**MIDTOWN COLLECTION AT HANNAH RIDGE FILING NO's 1 and 2
JUSTIFICATION FOR PUD MODIFICATIONS: PUBLIC ROAD ACCESS**

HANNAH RIDGE FILING NO's 1 and 2
MODIFICATIONS: PUBLIC ROAD ACCESS

PUD MODIFICATION TABLE (AS ALLOWED BY LDC SECTION 4.2.6.(F)(2)(g))

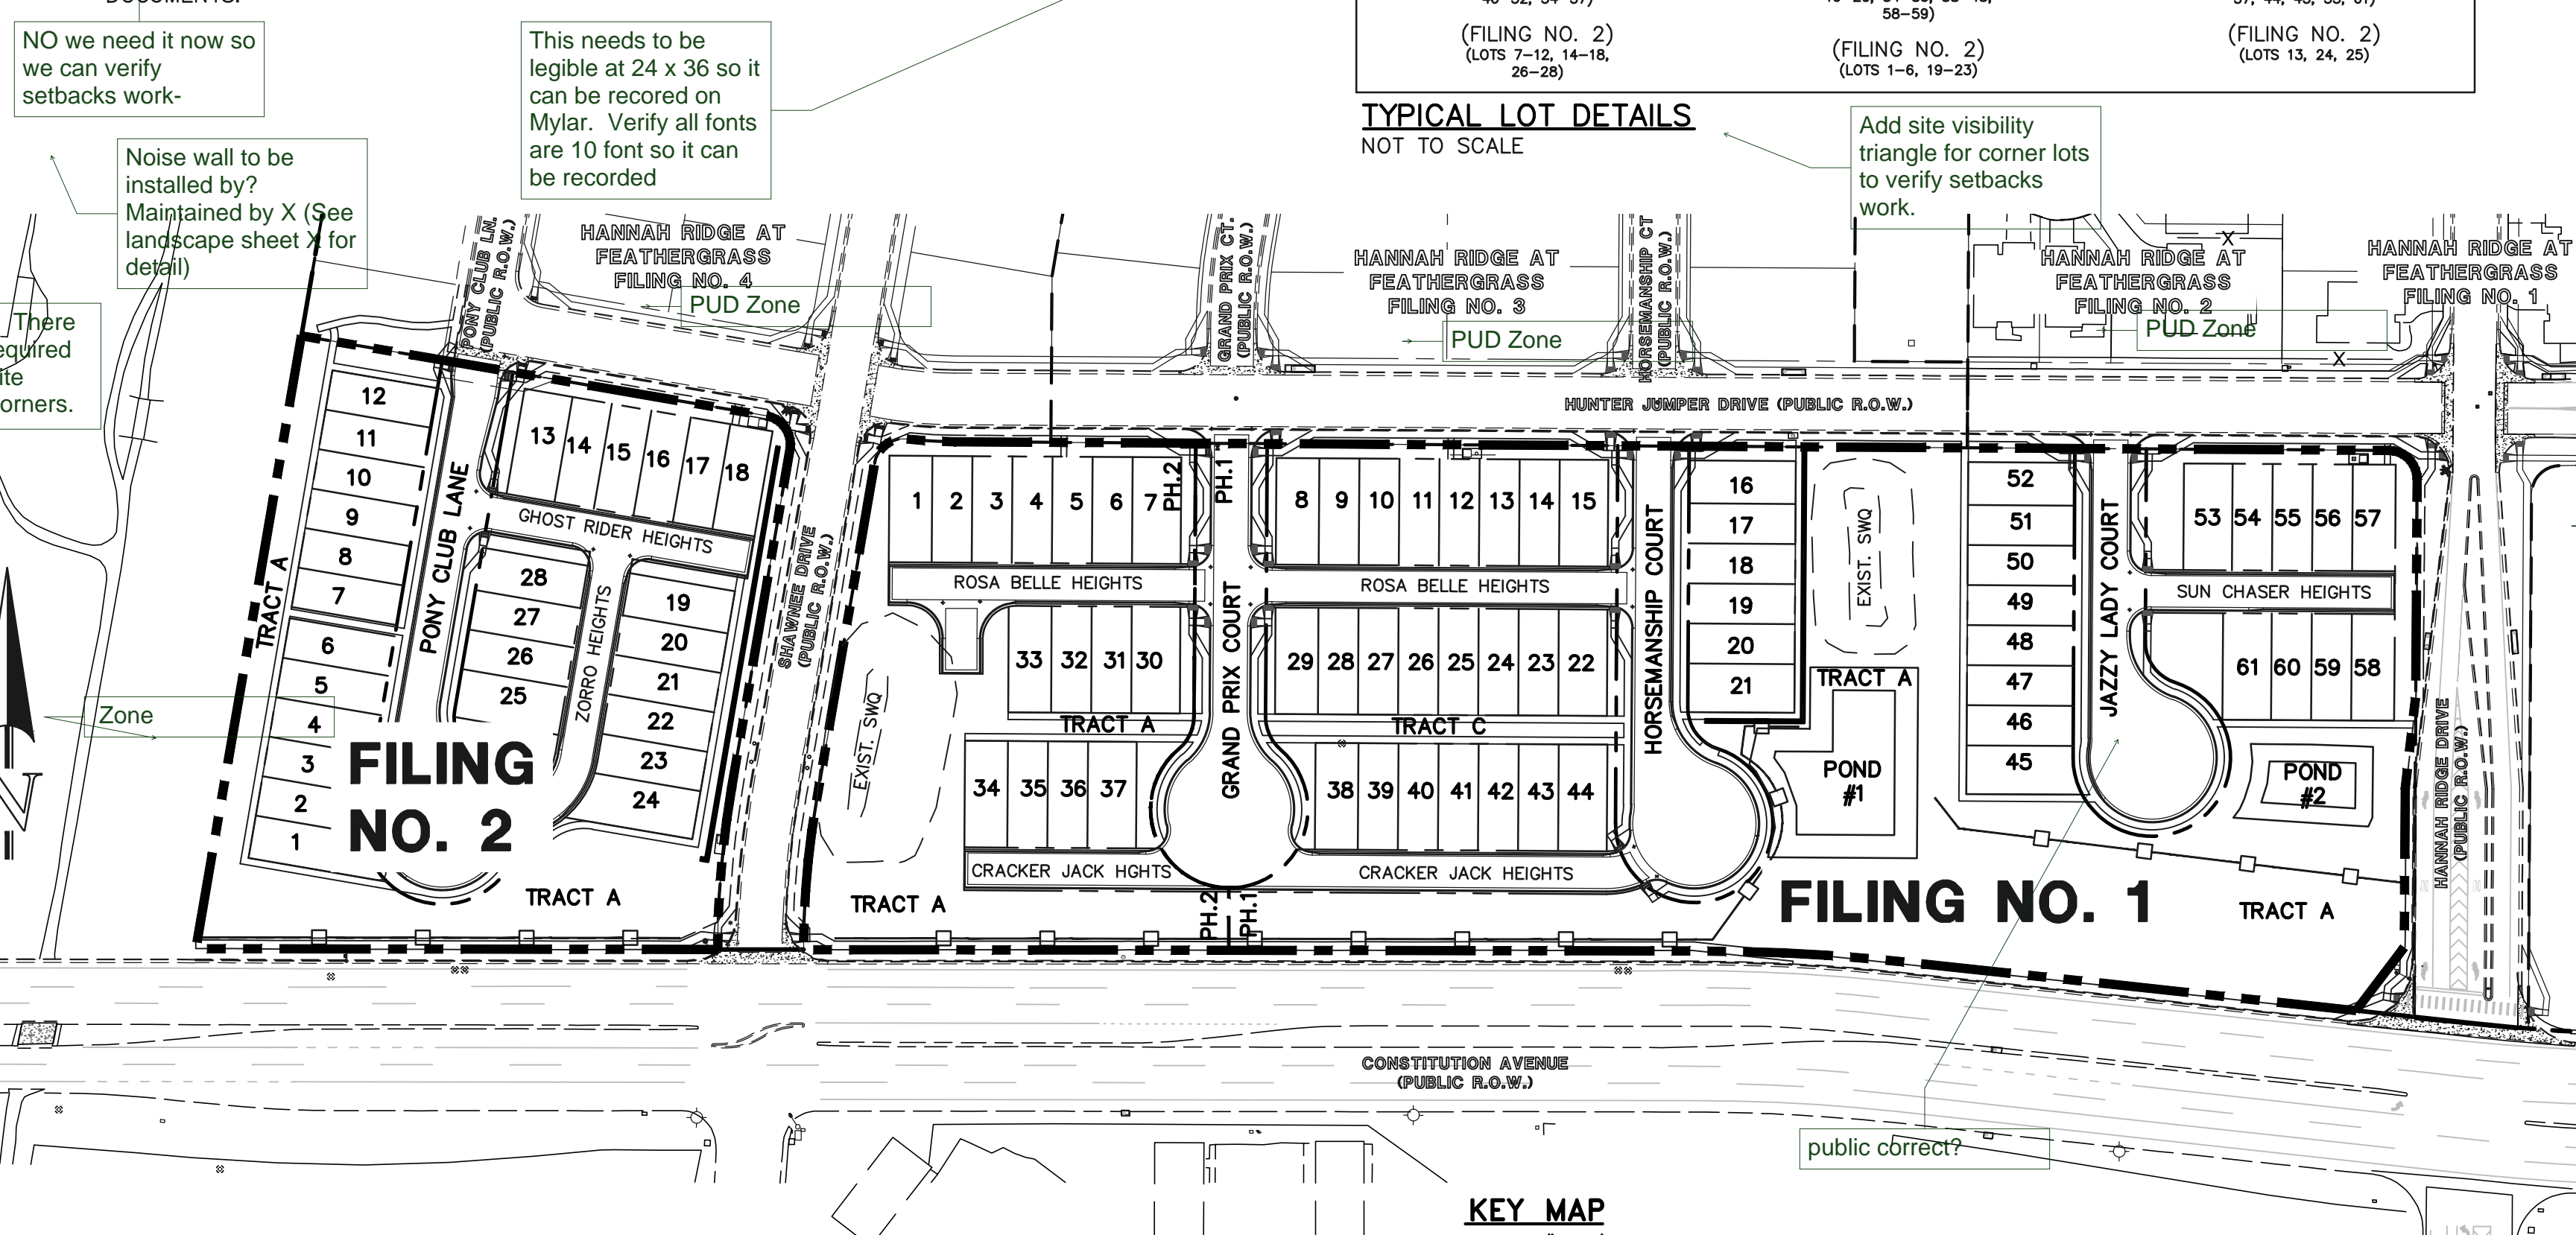
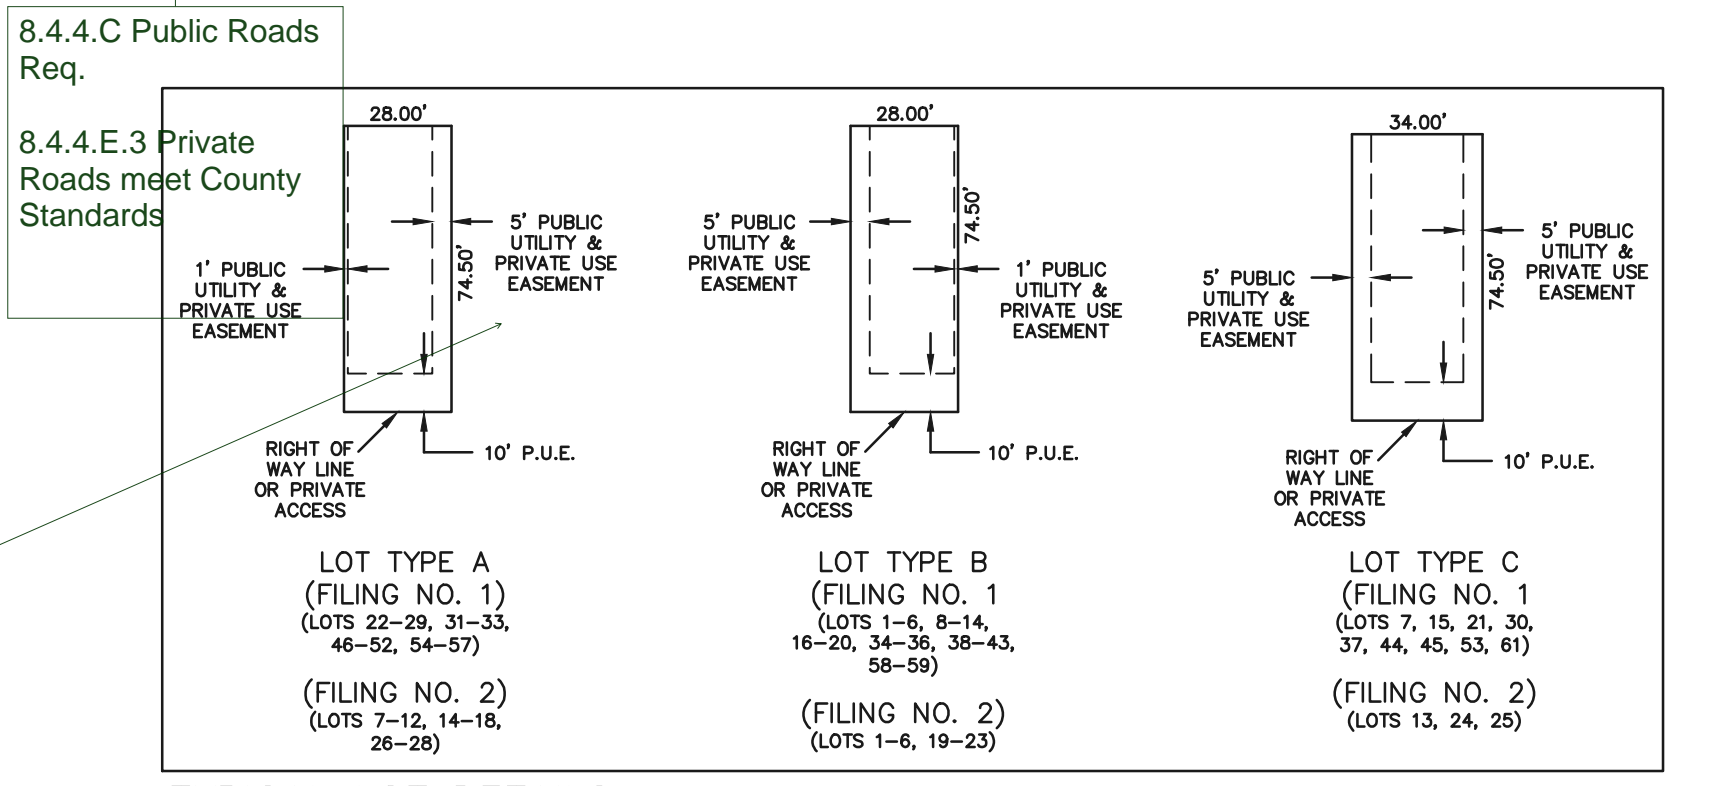
Provide fire department letter of support
